WEST SUSSEX COUNTY COUNCIL CONSULTATION

TO:	Arun District Council FAO: Andrew Wood
FROM:	WSCC - Highways Authority
DATE:	24 May 2021
LOCATION:	Tudor Close Public House Ferringham Lane Ferring BN12 5NQ
SUBJECT:	FG/86/21/DOC Approval of details reserved by condition imposed under ref FG/105/20/PL relating to Condition Nos 3 - car parking, 4 - materials & finishes, 5 - covered & secure cycle parking spaces, 6 - Arboricultural Impact Assessment, 8 - decentralised, renewable & low carbon energy and 9 - charging of electric vehicles
DATE OF SITE VISIT:	n/a
RECOMMENDATION:	More Information
S106 CONTRIBUTION TOTAL:	n/a

210809.1_R0_003

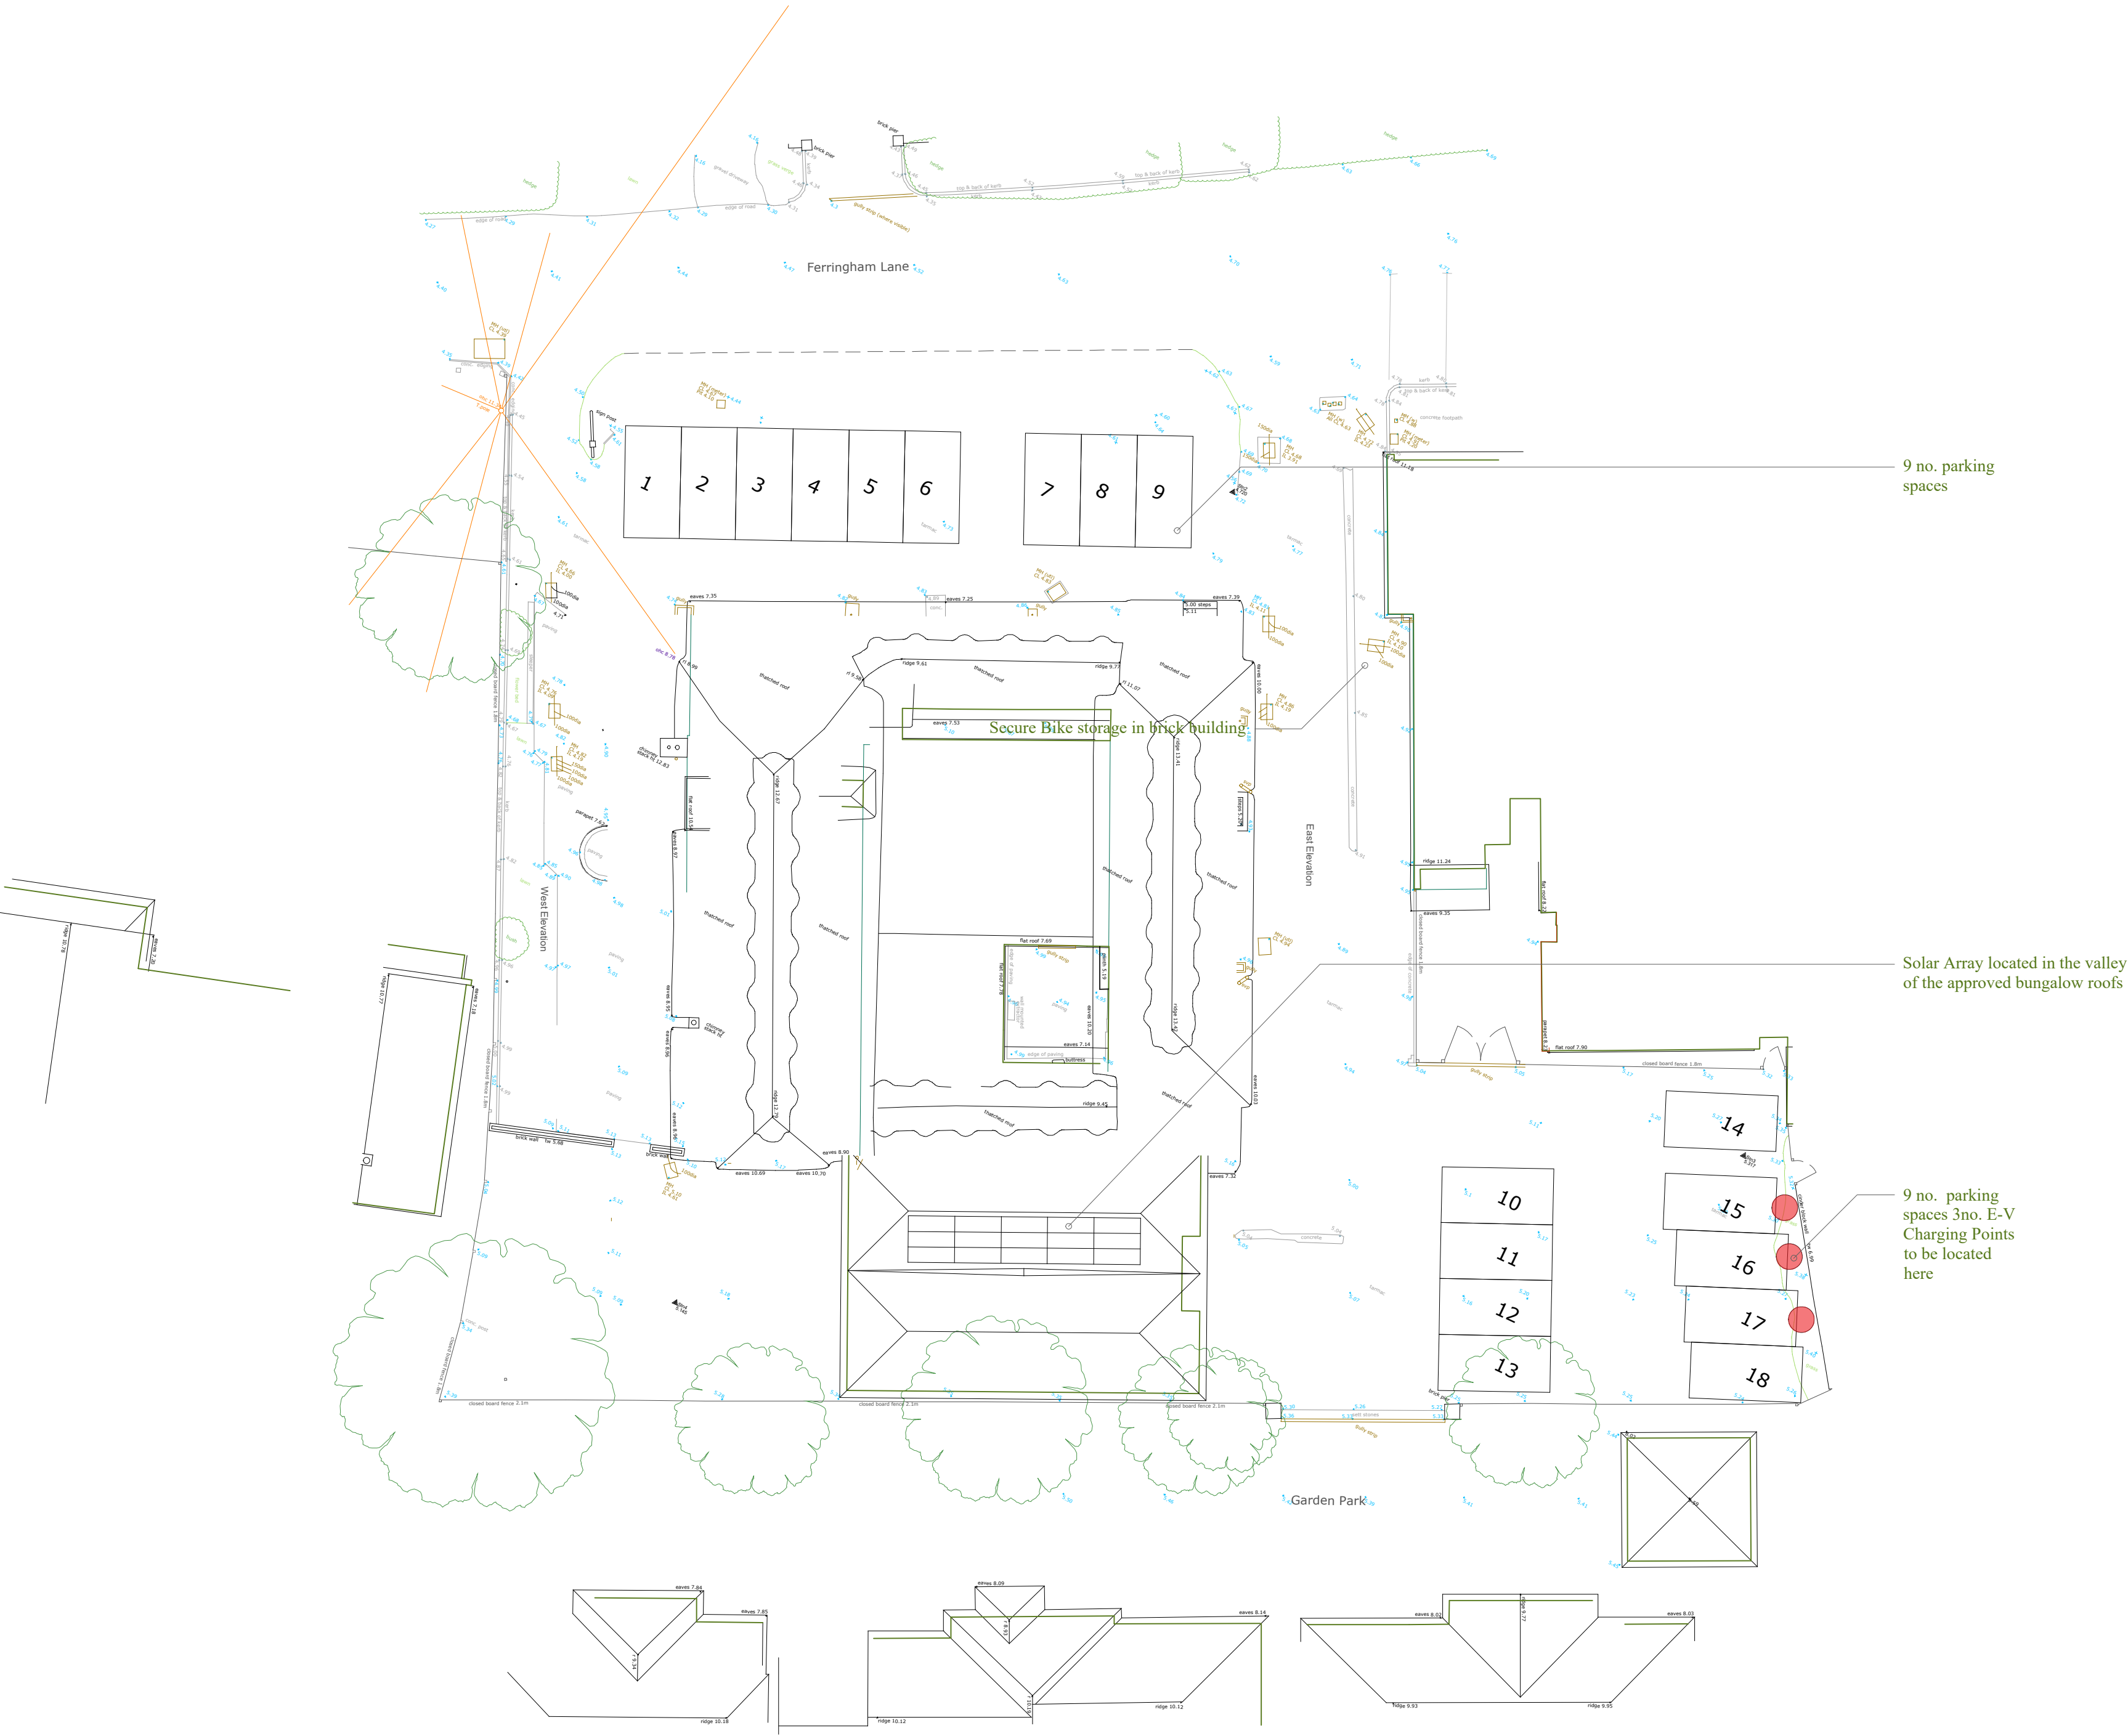
Condition 9 Electric Vehicle Charging

Condition 9 requires details of electric vehicle charging provision to be provided. The applicant has stated that they intend to provide 2 EV charging points to be located in the south east corner of the site. Table 2.2 in the Arun Parking Standards SPD requires all other development other than houses with a driveway and garage to have a minimum of 20% EV charging provision. This development proposes a total of 16 spaces and therefore should provide a minimum of 3 EV charging spaces to be in accordance with the SPD. The applicant should therefore provide an additional EV charging point.
